## OFFICIAL NOTICE OF DECISION

### **Project# 1005133**

**13DRB-70690 VACATION OF PUBLIC SIDEWALK EASEMENT  
13DRB-70691 PRELIMINARY/ FINAL PLAT APPROVAL**

ISAACSON AND ARFMAN PA agents for SED DEVELOPMENT, LLC request the referenced/ above actions for Tract N-1-B-2-A, SEVSN BAR RANCH zoned SU-1/ C-2 PERMISSIVE USES, located on the south side of COORS BLVD BYPASS NW west of EAGLE RANCH RD NW containing approximately 1.9788 acres. (B-13)

PLAT OF  
**TRACTS N-1-B-2-A-1 AND N-1-B-2-A-2**  
**SEVEN-BAR RANCH**

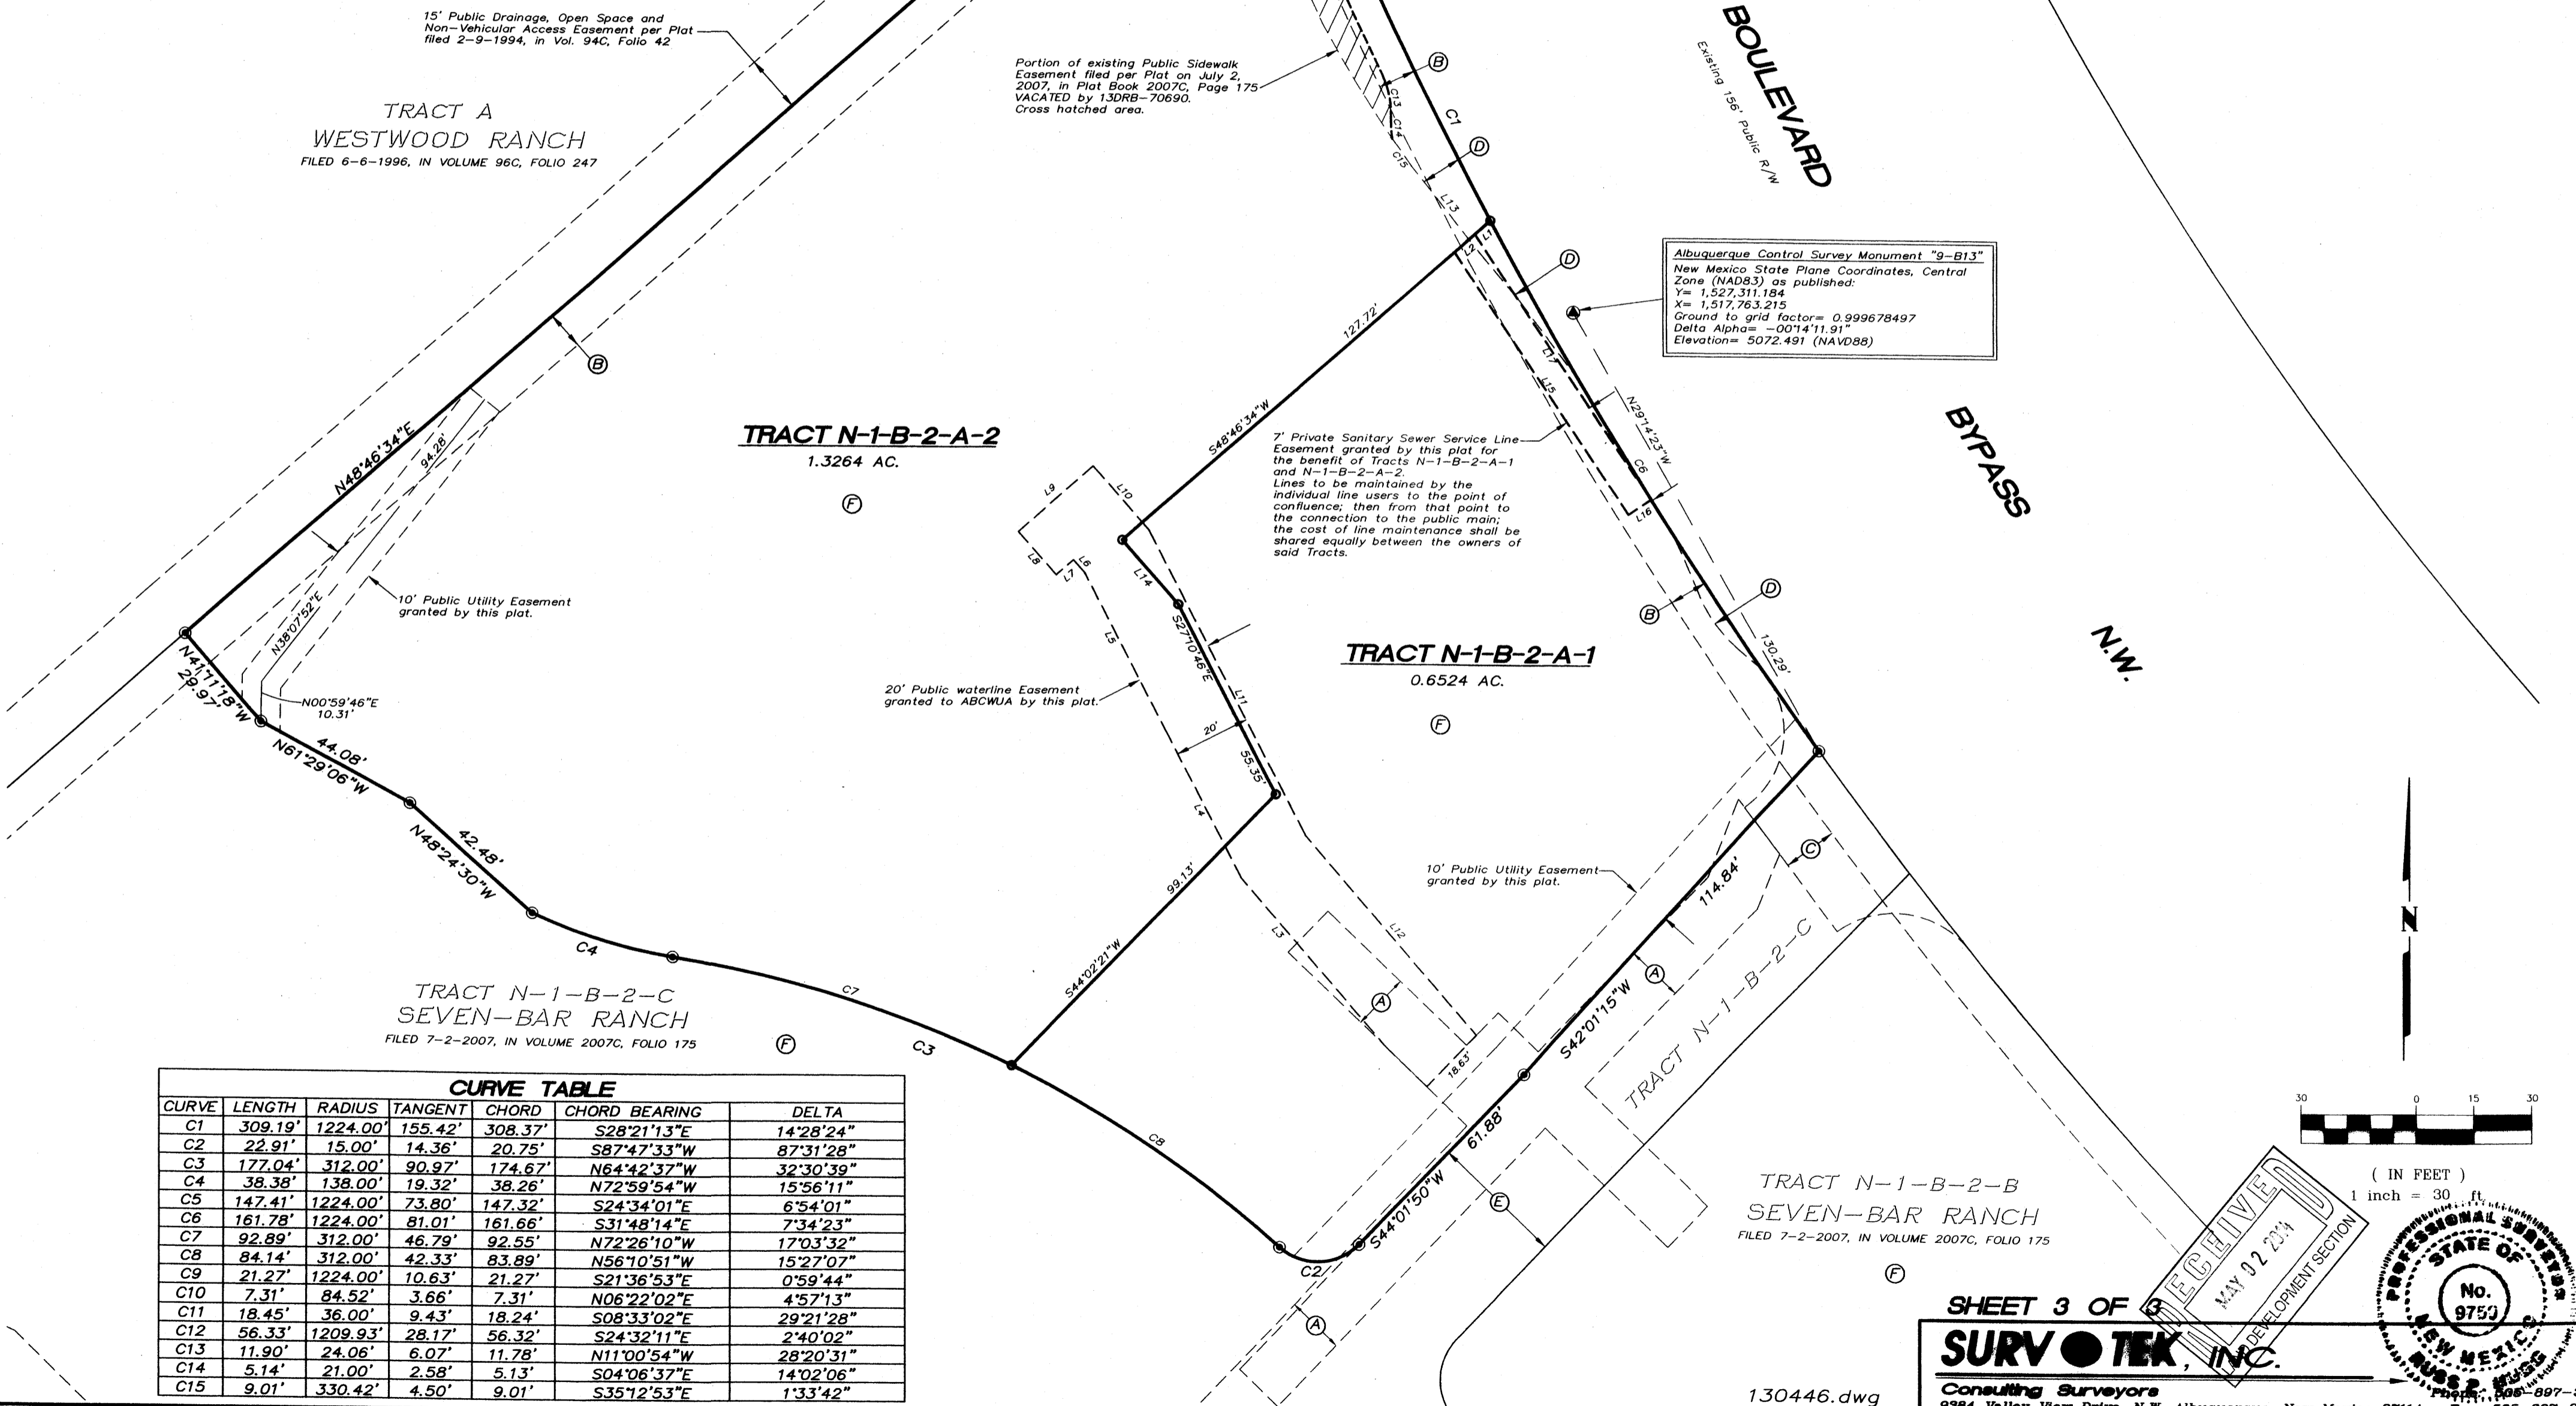
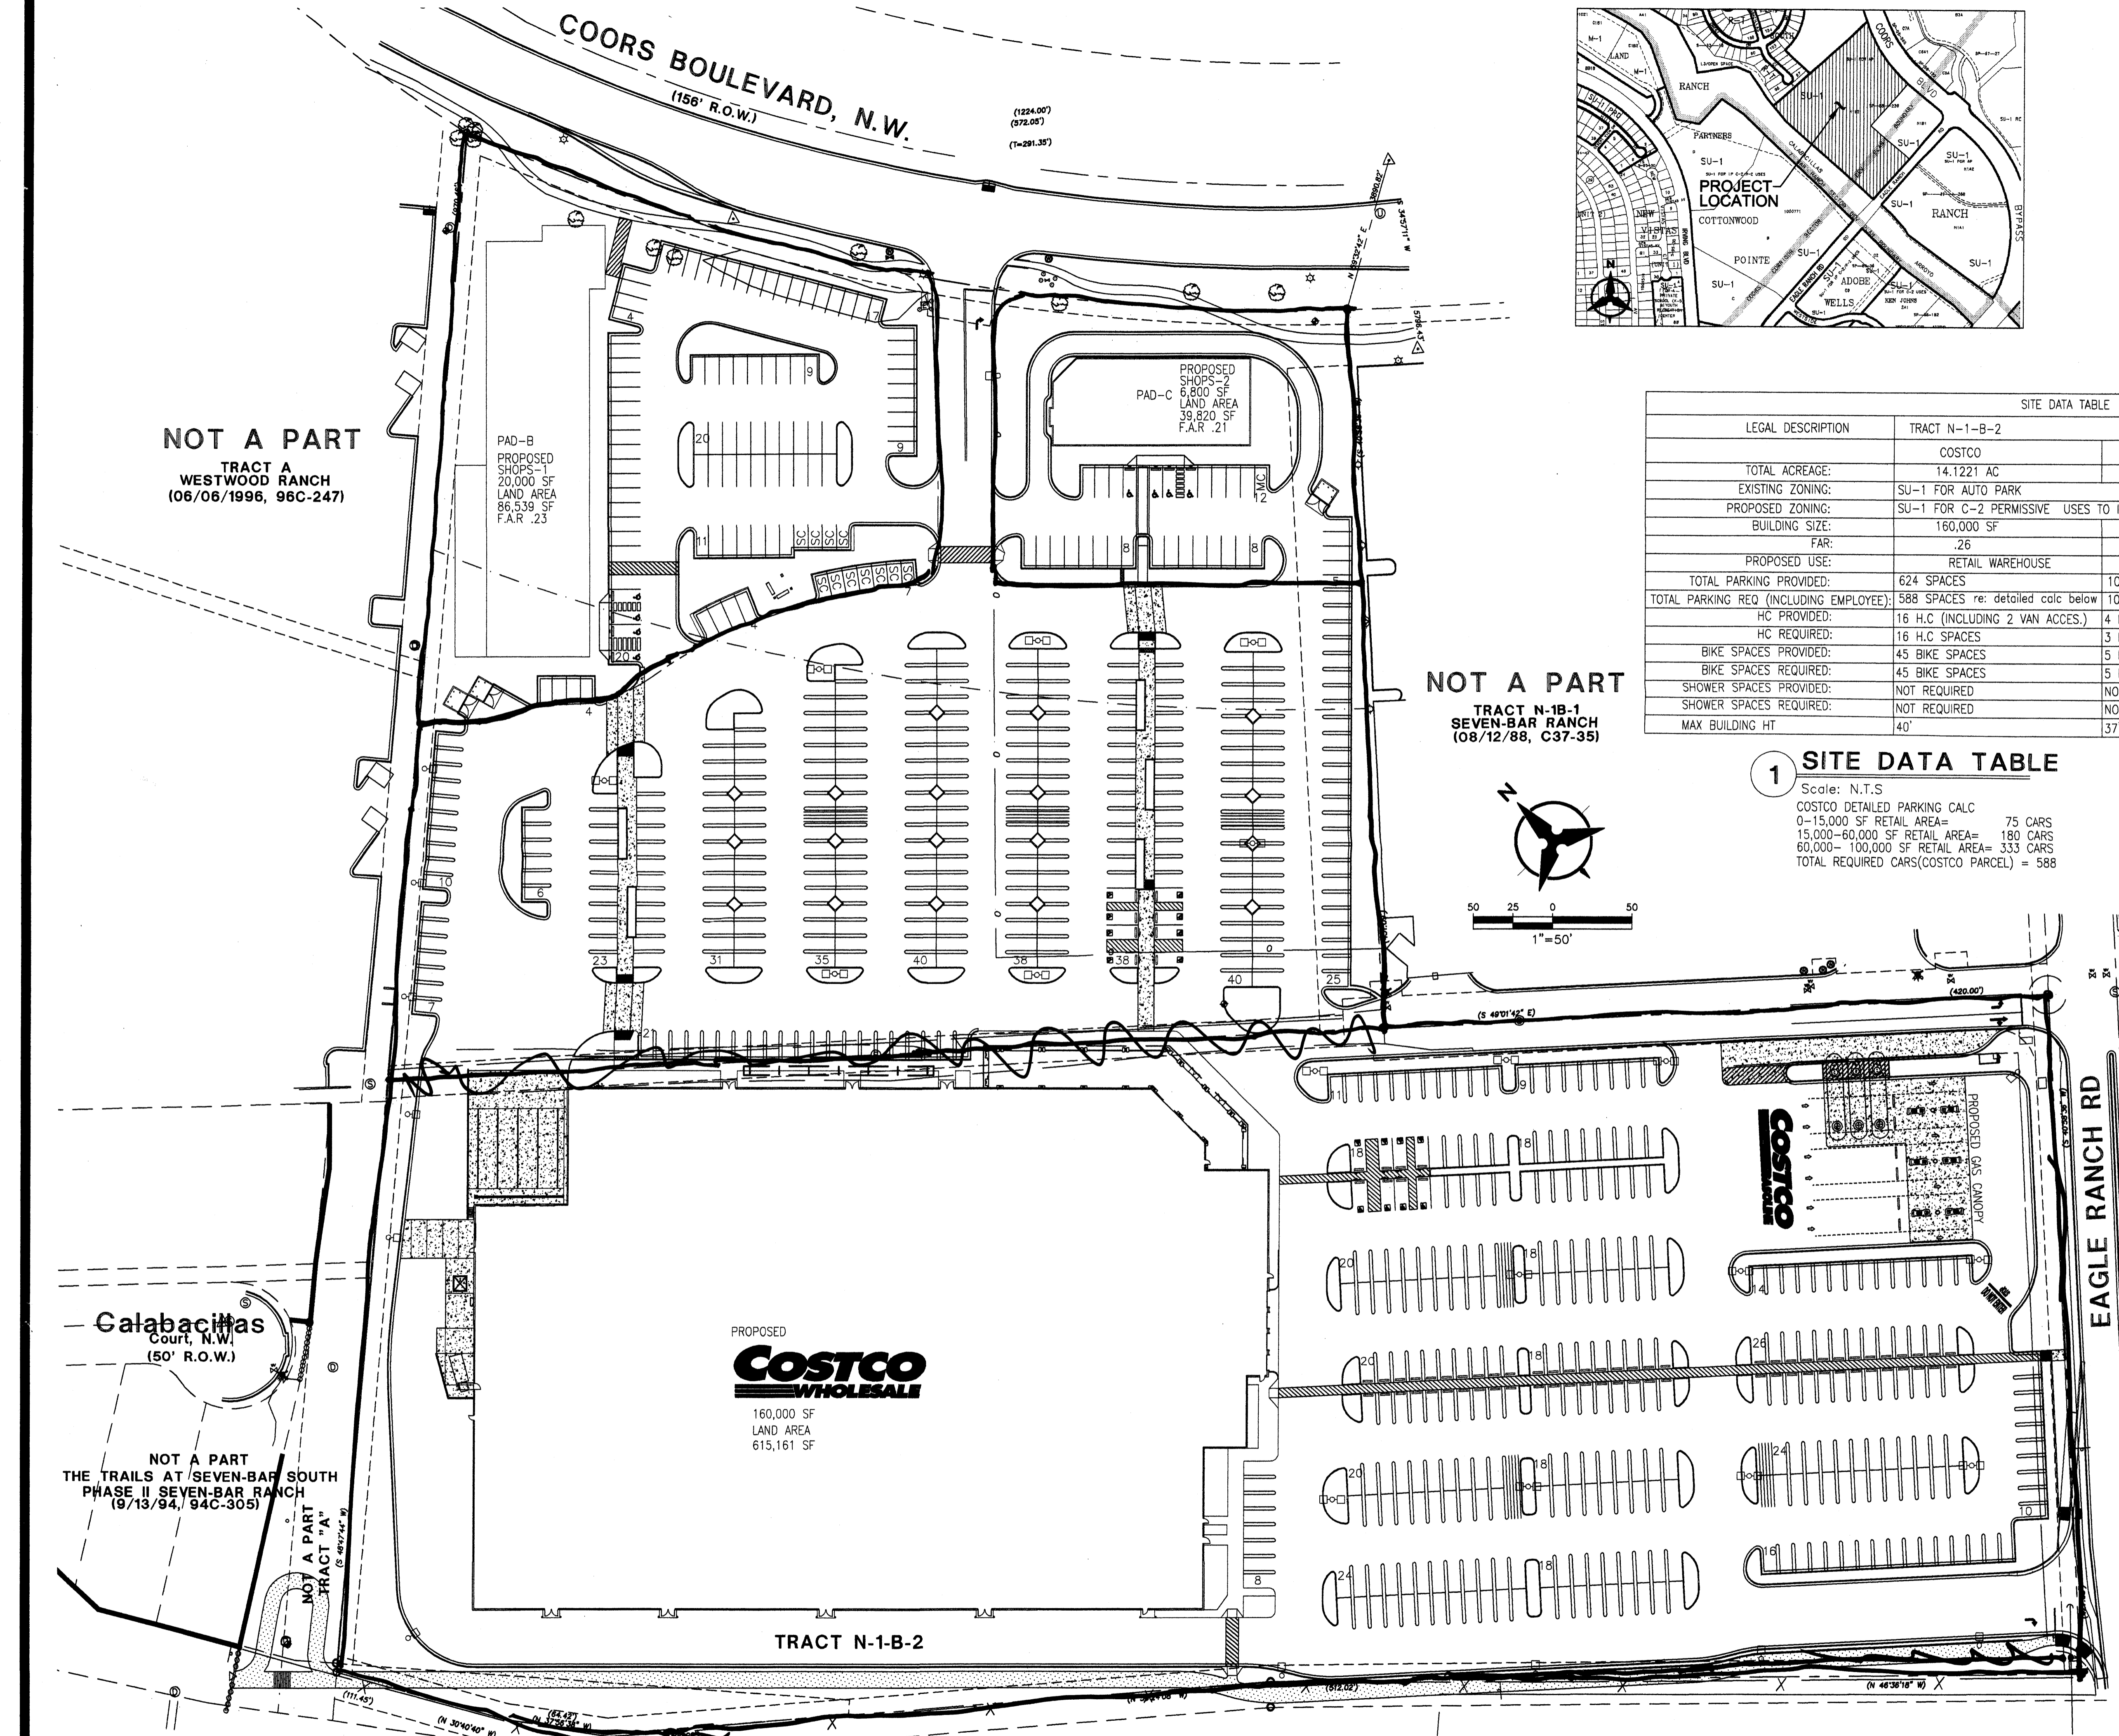
What is the status of the relocation of the existing sidewalk?

Provide a timeline for the relocation of the existing sidewalk.

At the October 23, 2013 Development Review Board meeting, the vacation was approved as shown on Exhibit B in the Planning file per section 14-14-7-2(A)(1) and (B)(1)(3) of the Subdivision Ordinance. The Preliminary/ Final Plat was indefinitely deferred pending sidewalk relocation.
